Our Ref: 10015552  
Your Ref: TR030001  
Date: 15 November 2013

**Application by Able Humber Ports Limited for an Order granting Development Consent for the Able Marine Energy Park**

Thank you for giving the Environment Agency an opportunity to comment on the additional submissions made by Able Humber Ports Limited (the applicant) in respect of their habitat compensation proposals.

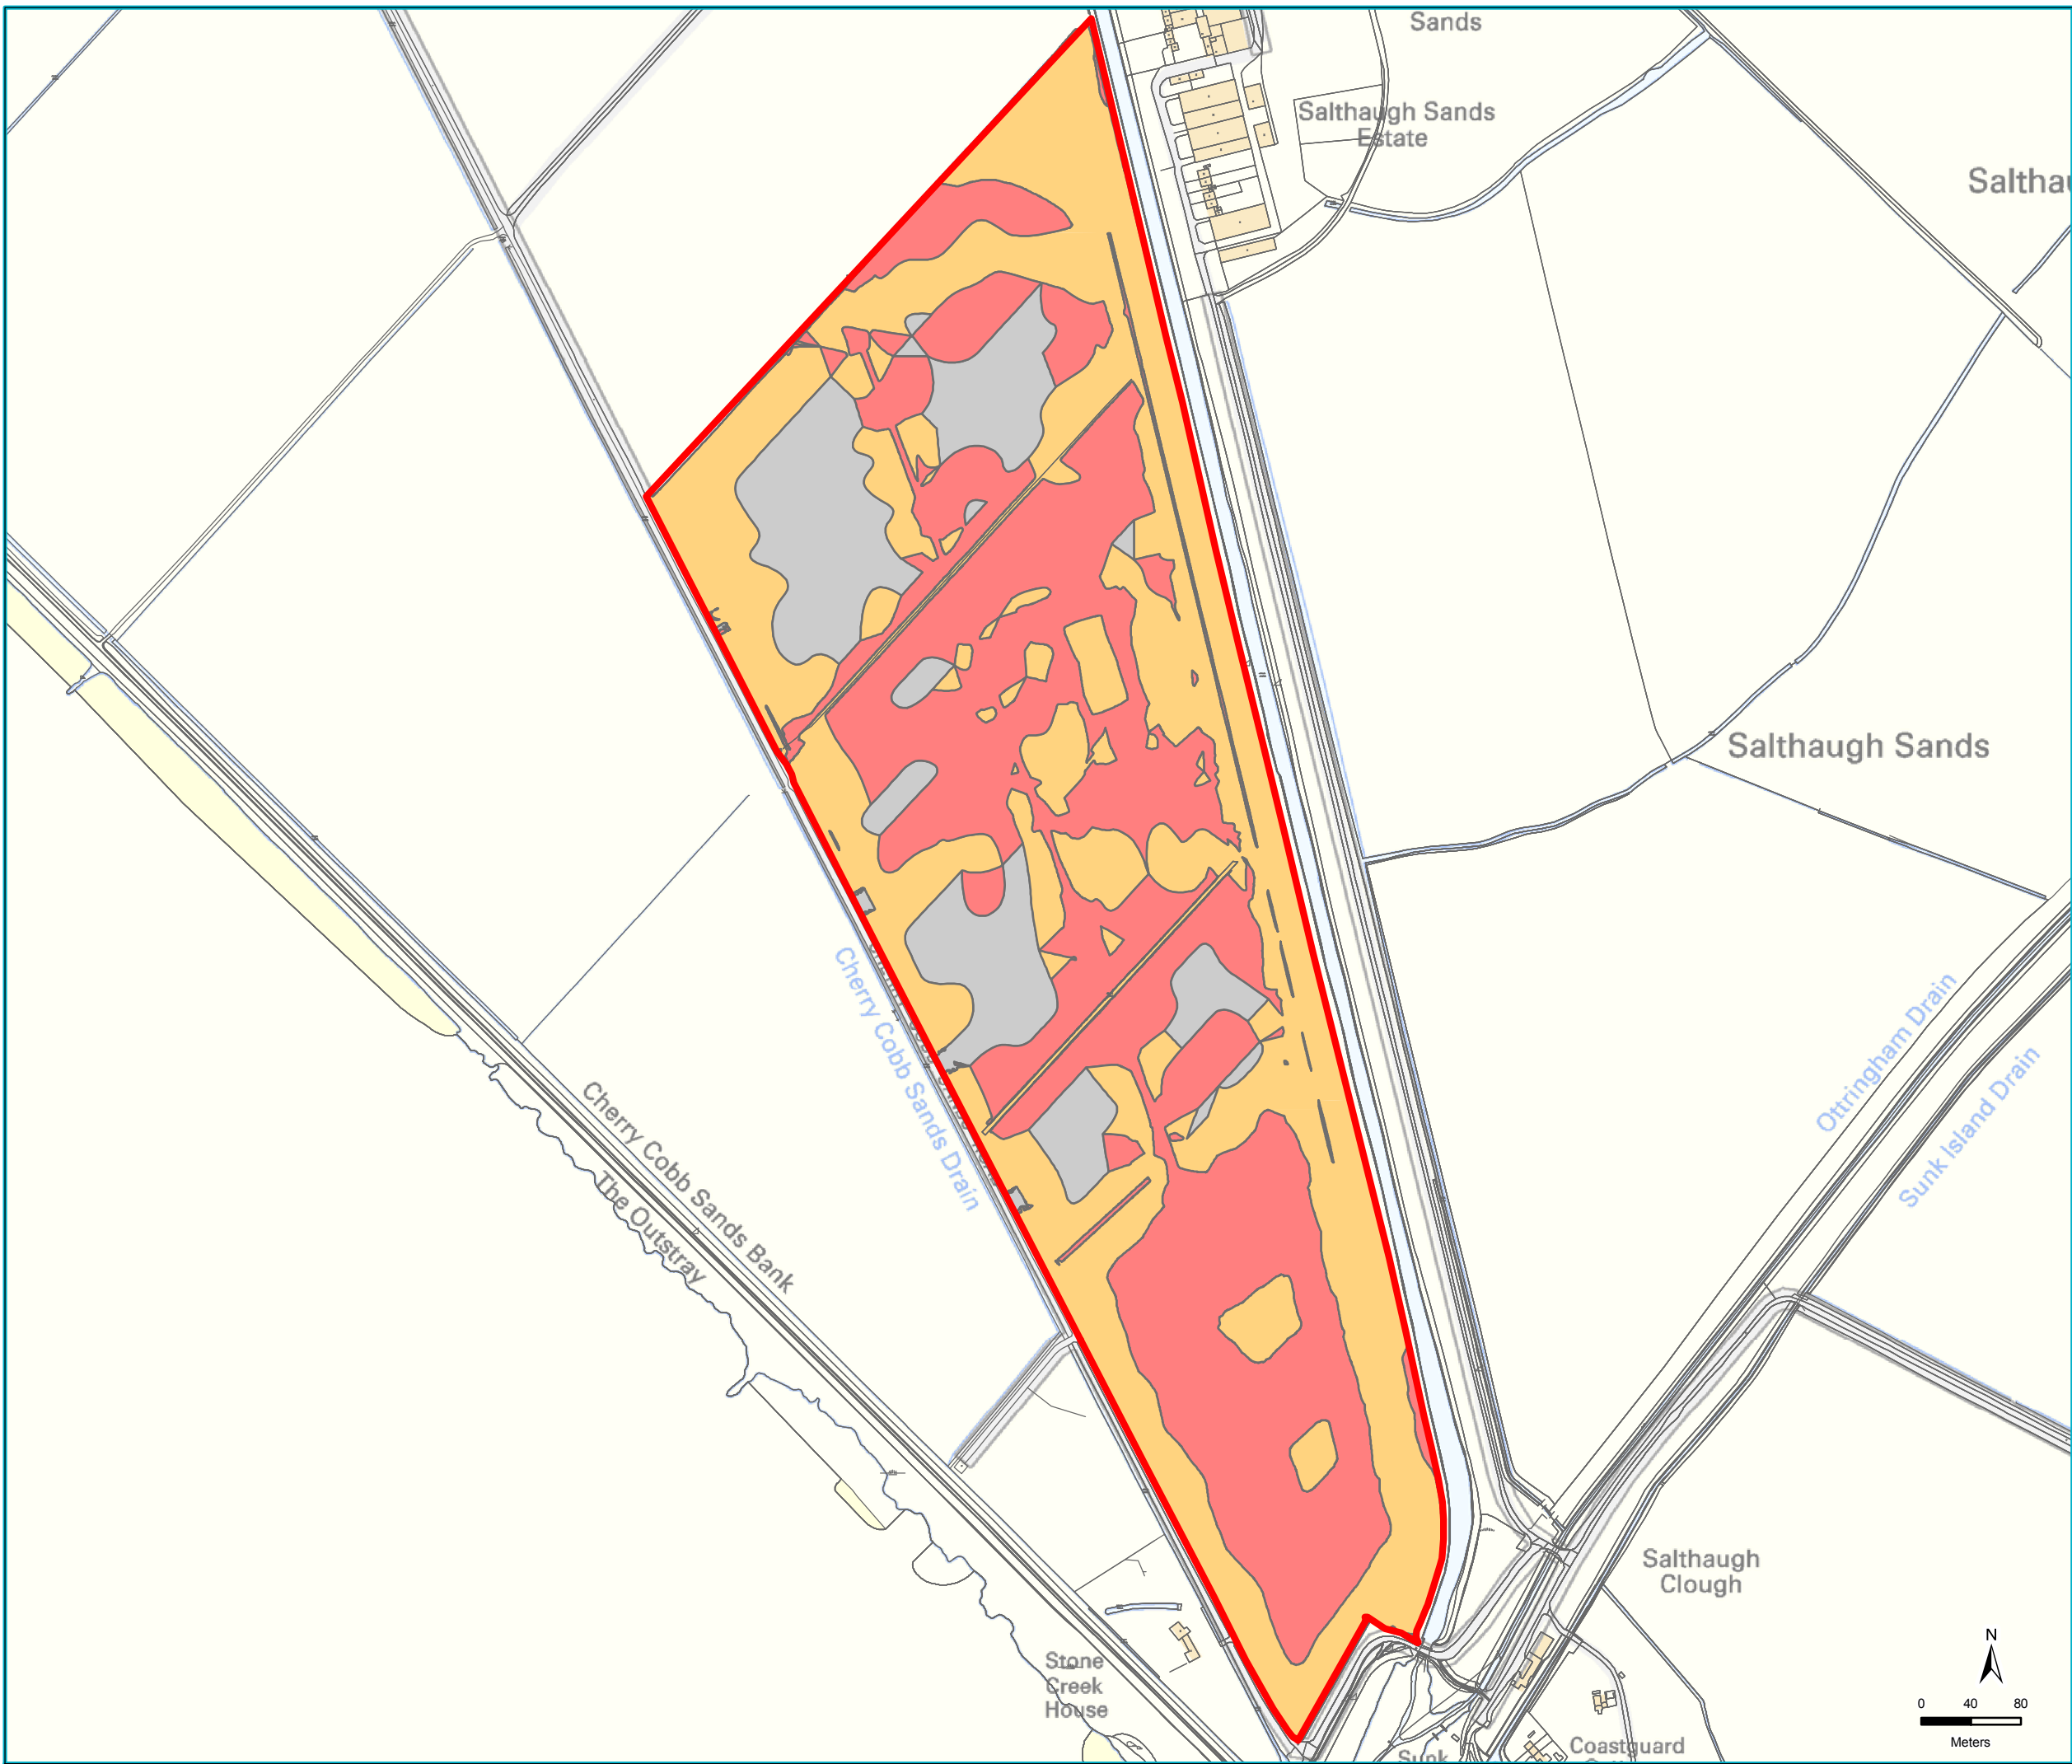
We have provided advice to East Riding of Yorkshire Council in respect of the various planning applications, which the applicant has submitted in respect of the Cherry Cobb Sands site. In summary, we can advise that all the issues raised in respect of this site have now been resolved with the exception of the detailed pond design (Condition 7 of permission ref: 12/04154). On receipt of the further information requested in respect of the pond, we should be able to support the discharge of this planning condition. We provide a short summary and copy correspondence relating to our consultation involvement for the original planning application at this site at Appendix B and subsequent discharge of planning conditions at Appendix C for your information.
